Notice of Modification

Section 96(2) of the *Environmental Planning and Assessment Act 1979*

The development consent (SSD_5170) for the Bengalla Continuation Project, granted by the Secretary as delegate of the Minister for Planning, on 3 March 2015.

APPENDIX 2 DEVELOPMENT LAYOUT

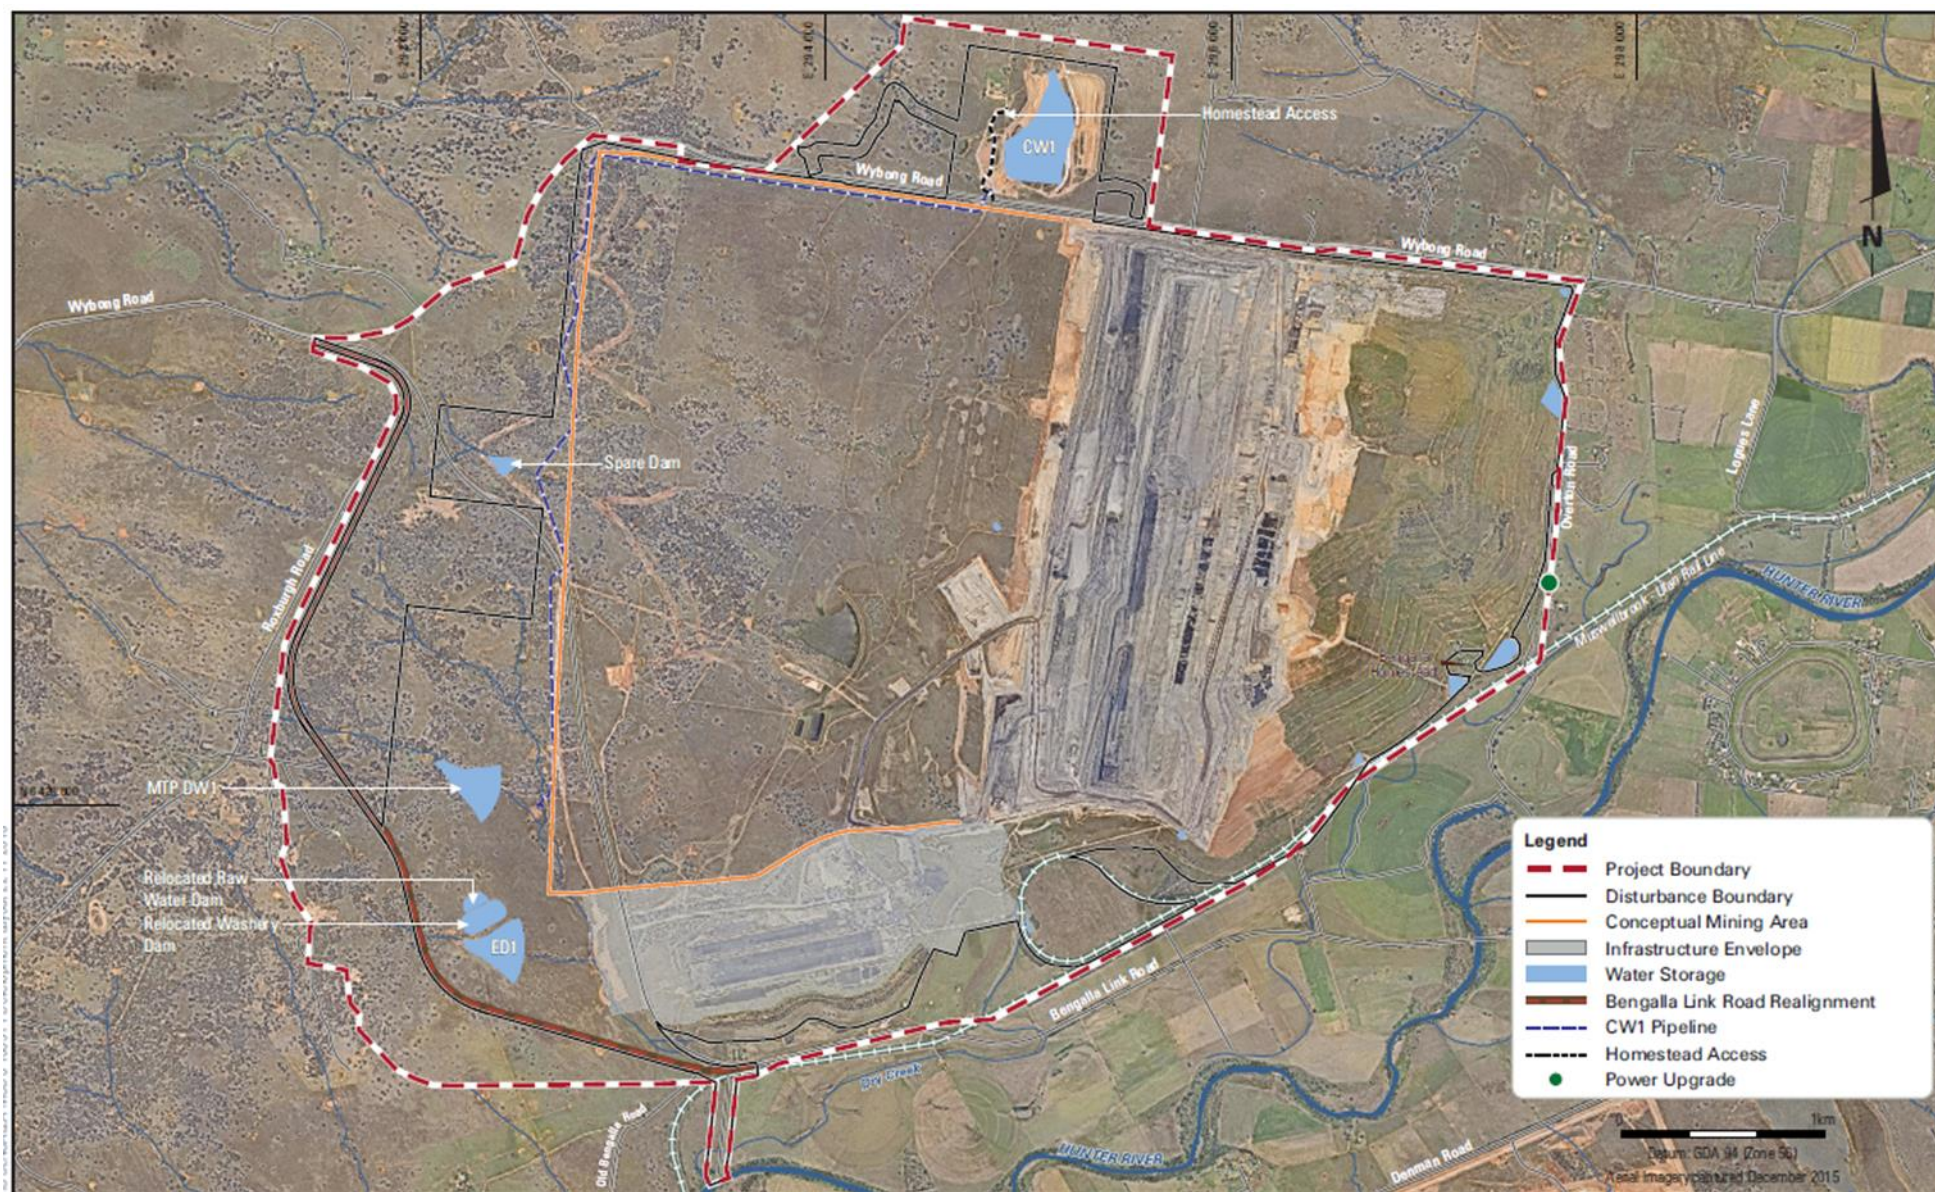
2. In condition 2(a) of Schedule 2 after "SEE (Mod 1)" delete "and SEE (Mod 2)" replacing with ",SEE (Mod 2) and SEE (Mod 3)"
3. In Appendix 2, delete the figure and replace with the following:
